102 E. Pikes Peak, Suite 500  
Colorado Springs, CO 80903  
(719) 955-5485

January 15, 2020

**RE: Homestead at Sterling Ranch Filing No.2  
Response to Comment Letter.**

LOTS 36-41 STORM SEWER (PRIVATE)
SCALE 1"=30'

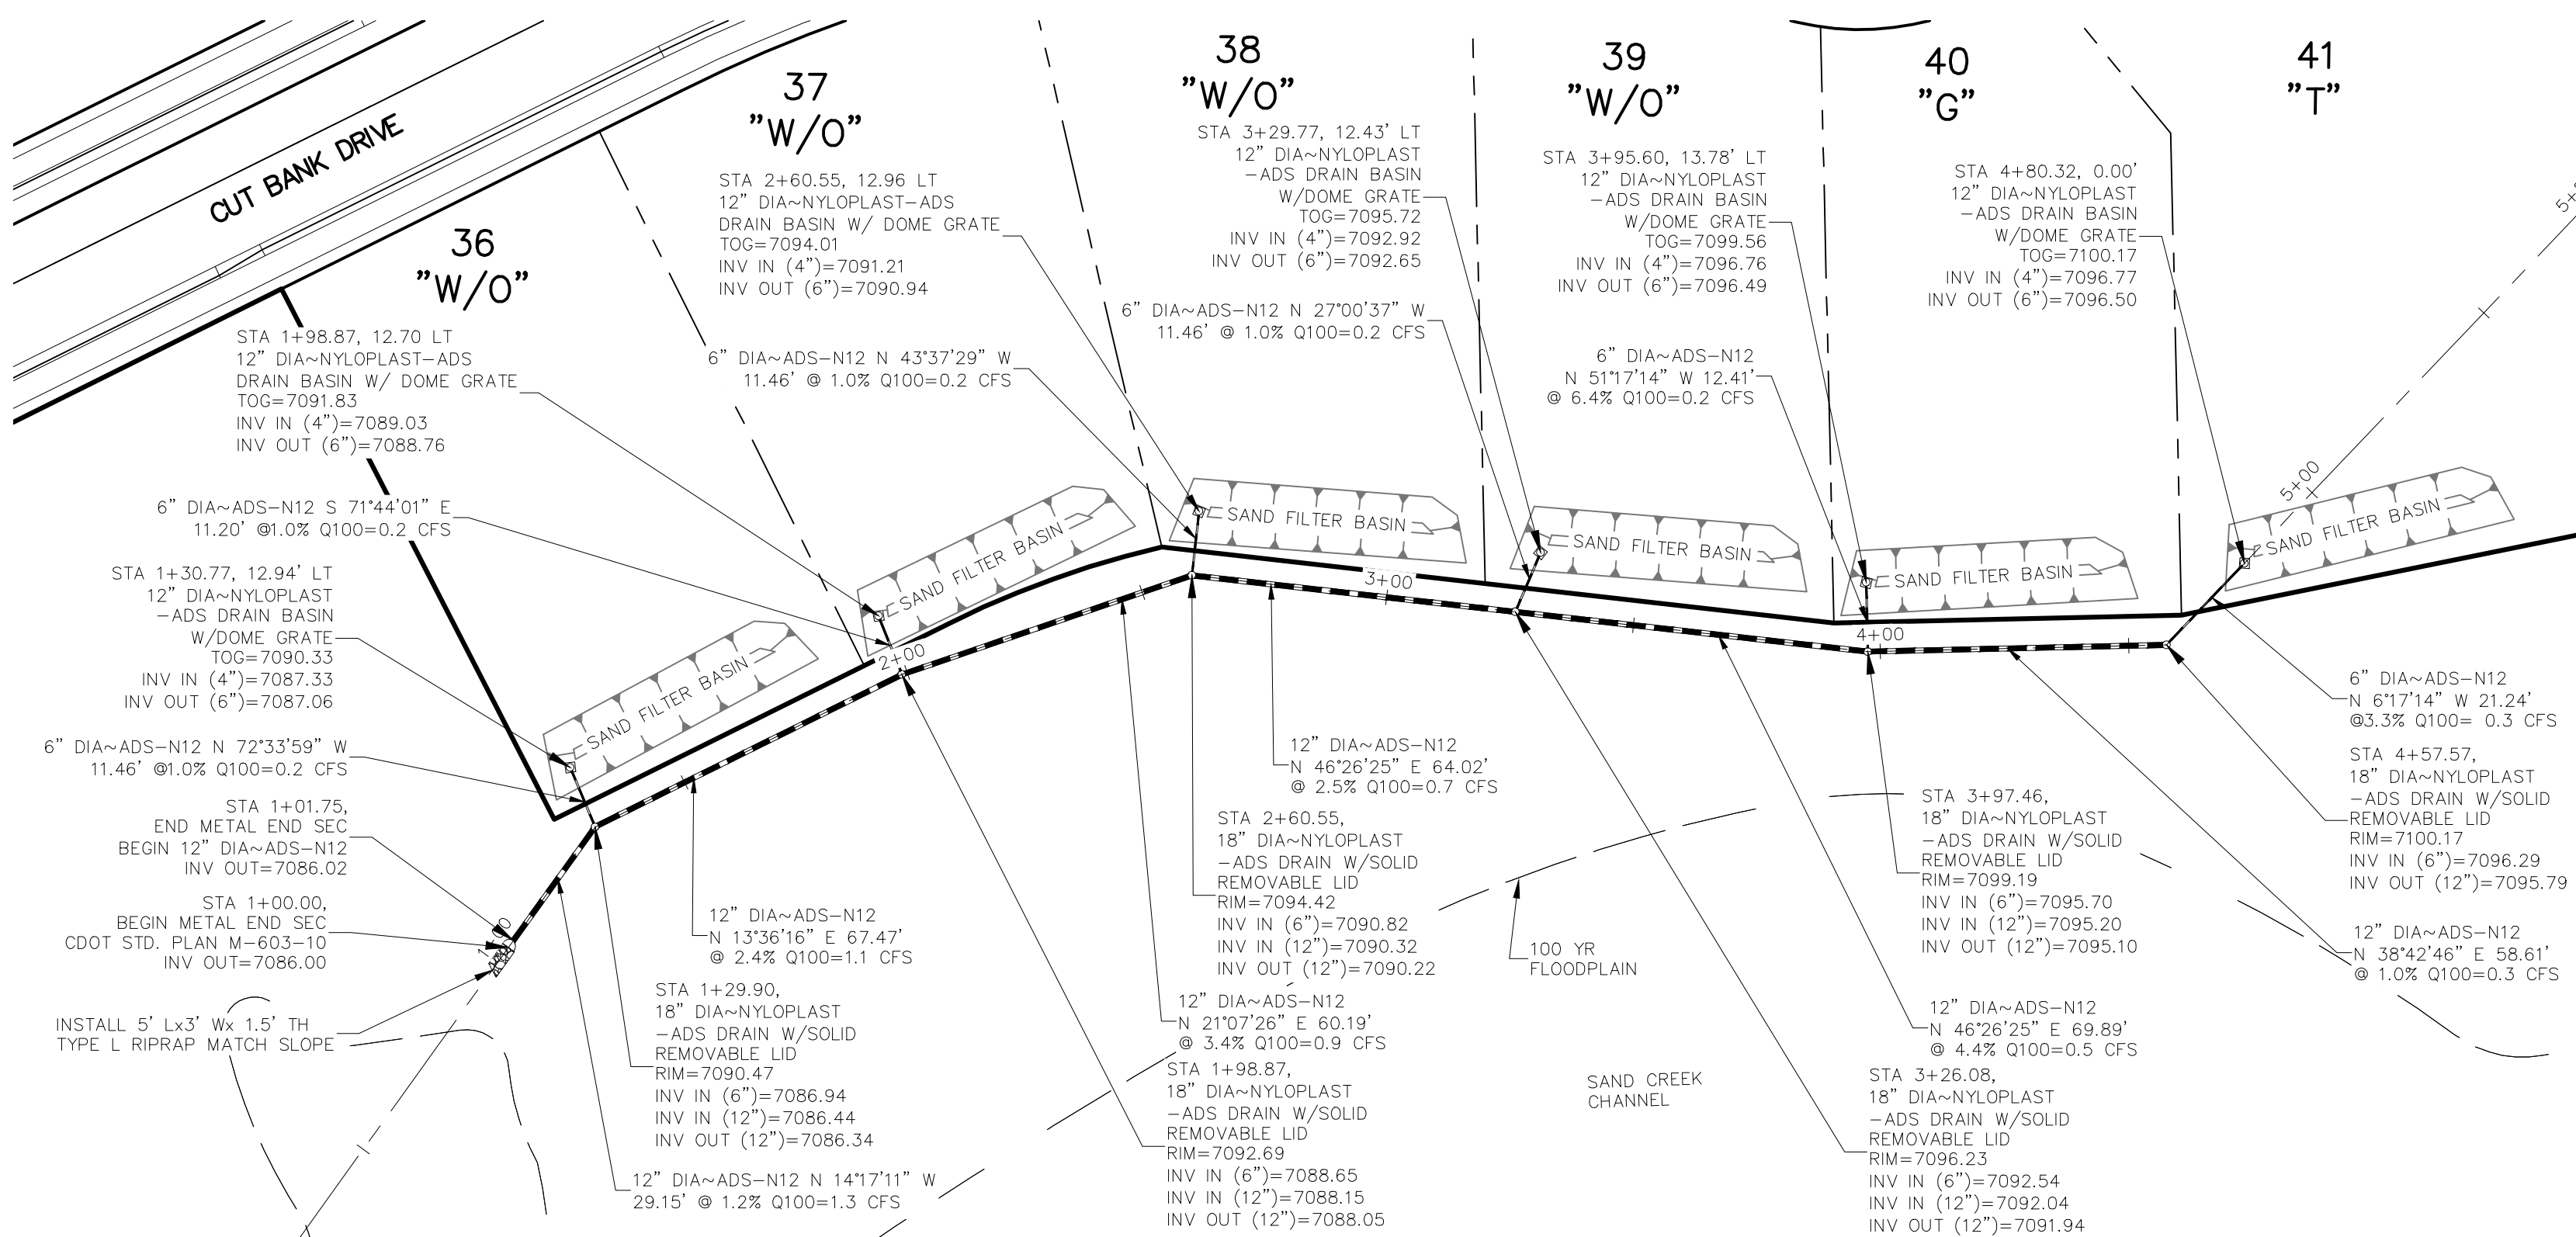
9. **Additional discussion is necessary regarding the multiple SFBs proposed in the rear yards along the creek. O&M manual and maintenance agreement details need to be complete.**  
**Additional discussion has been added to the FDR and details added to the O&M manual.**
